Subject: AB/151/21/HH - Alterations to kitchen and replacement windows to west elevation, 11 King Street, Arundel

In respect of the above planning application the **Arun District Conservation Area Advisory Panel** wish to make the following comments:

client	project	drawing	date	drawn	drawing no	revision
Cliff Durant	Kitchen alterations & new windows at 11 King Street Arundel, BN18 9BJ	Proposed Sections	Nov 21	pd	0352 / 105	A
			scale 1:20 @ A3	CAD file name:

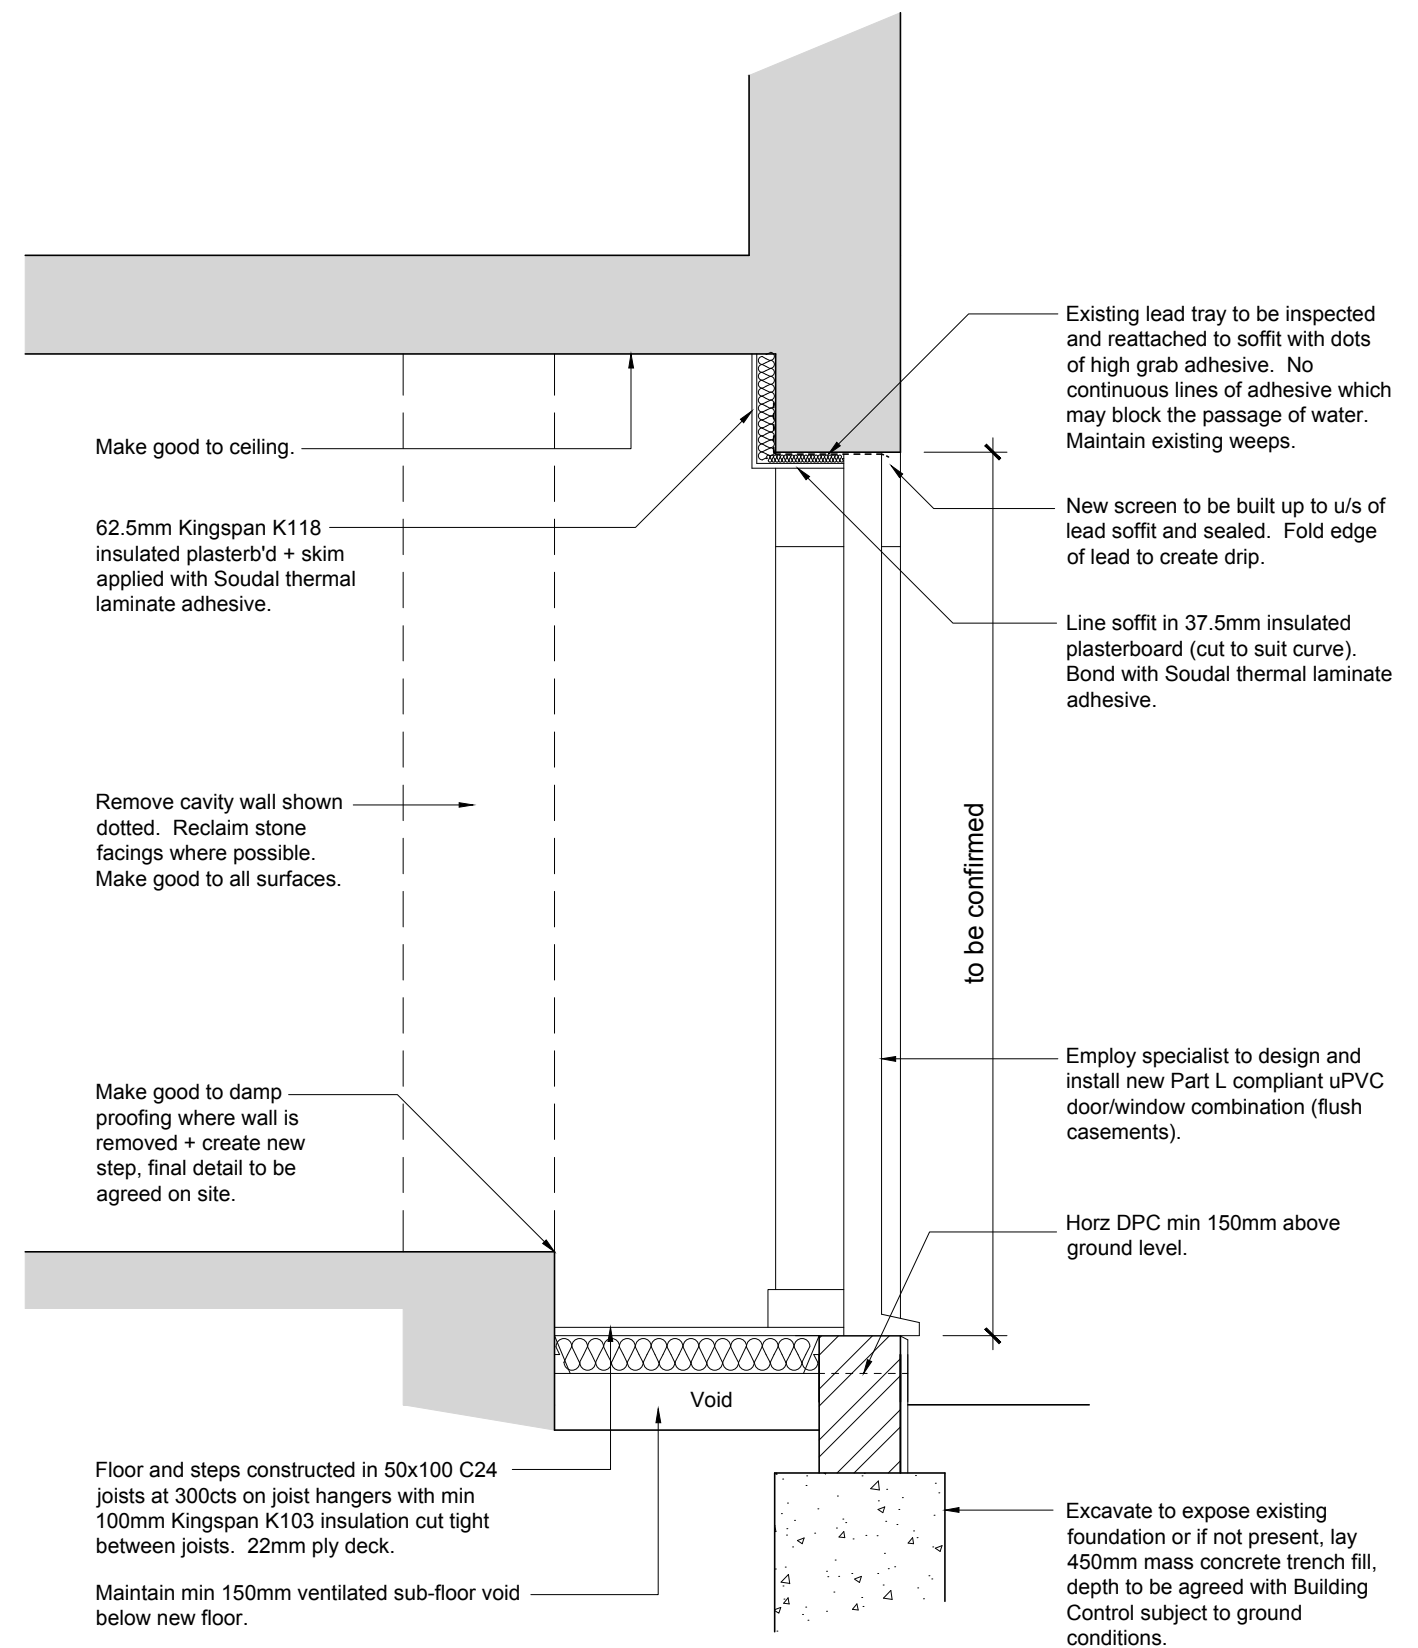
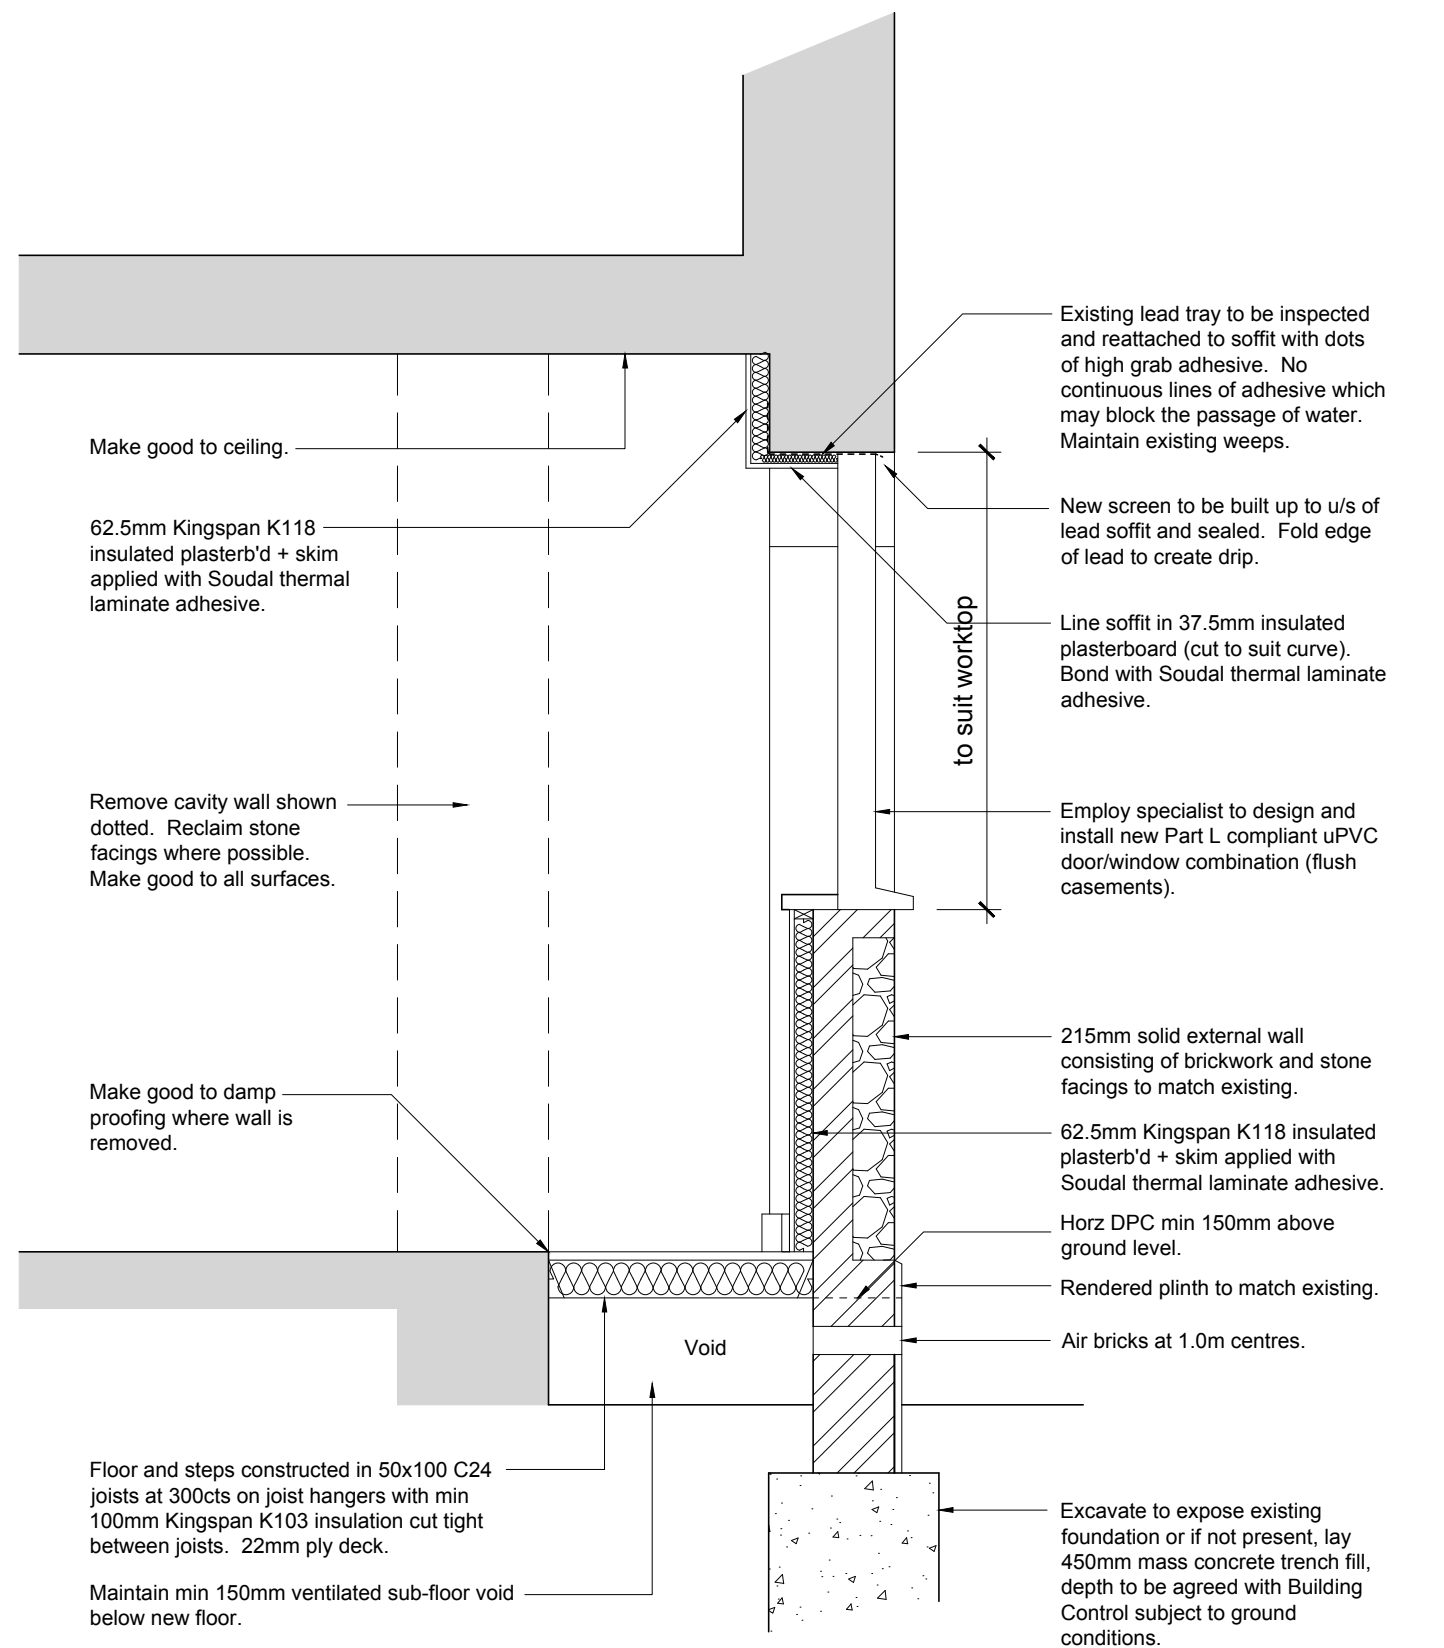
The proposal includes the replacement of painted timber windows with pvcu ones on the west elevation of the property. This elevation is not readily visible from public areas and there would be limited views from private ones within the conservation area. Some thought has been given to these proposed windows to ensure that they contain flush fitting casements i.e the casements do not protrude from the window frame. Even so, the Panel's view is that the pvcu windows, no matter how traditionally designed, will lack the subtlety of finish, proportion and appearance of painted timber and will detract from the appearance of the building.

- (1) there will be an adverse effect on the appearance of the building which, although relatively modern, is of an extremely high quality traditional vernacular design. Traditional painted timber fenestration is an essential part of that quality, and
- (2) the grant of planning permission could set a precedent for the use of pvcu fenestration on the street elevation of the property and in the wider locality to the detriment of the special character, significance, and appearance of the conservation area.

If the Council comes to a view that a refusal cannot be warranted in this particular case then it is strongly recommended that an Informative be attached to the planning permission making it clear that the grant of planning permission for the use of pvcu fenestration should not be taken as a precedent for its use on the street elevation of the property or in the wider conservation area.
